## **50 HOUSE DEVELOPMENT OFF SHEPLEY ROAD, STOCKSMOOR**

### **STRONG OBJECTION – APPLICATION REFERENCE 2024/62/91242/E**

Saxton - 3 Bed 4 Person
87.2 sq.m / 939 sq.ft

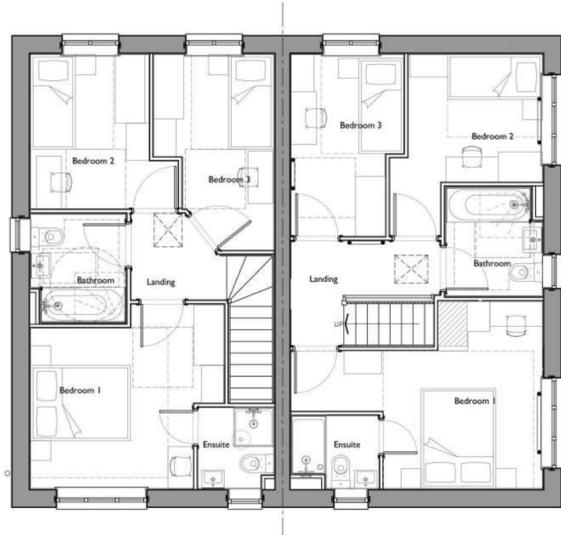
Design elements such as entrance canopies and fenestration details are generic, poor, outdated, lack any imagination and are not in keeping with local design. House types submitted have conflicting roof details. Generic roof details have been submitted when

reduced roof pitches could have been specified to minimise impact – The Saxton is a prime example. The layout and orientation of properties shows no effort to take advantage of the fantastic surroundings available or promote a high quality of living and appears entirely driven by a need to meet road layout requirements.
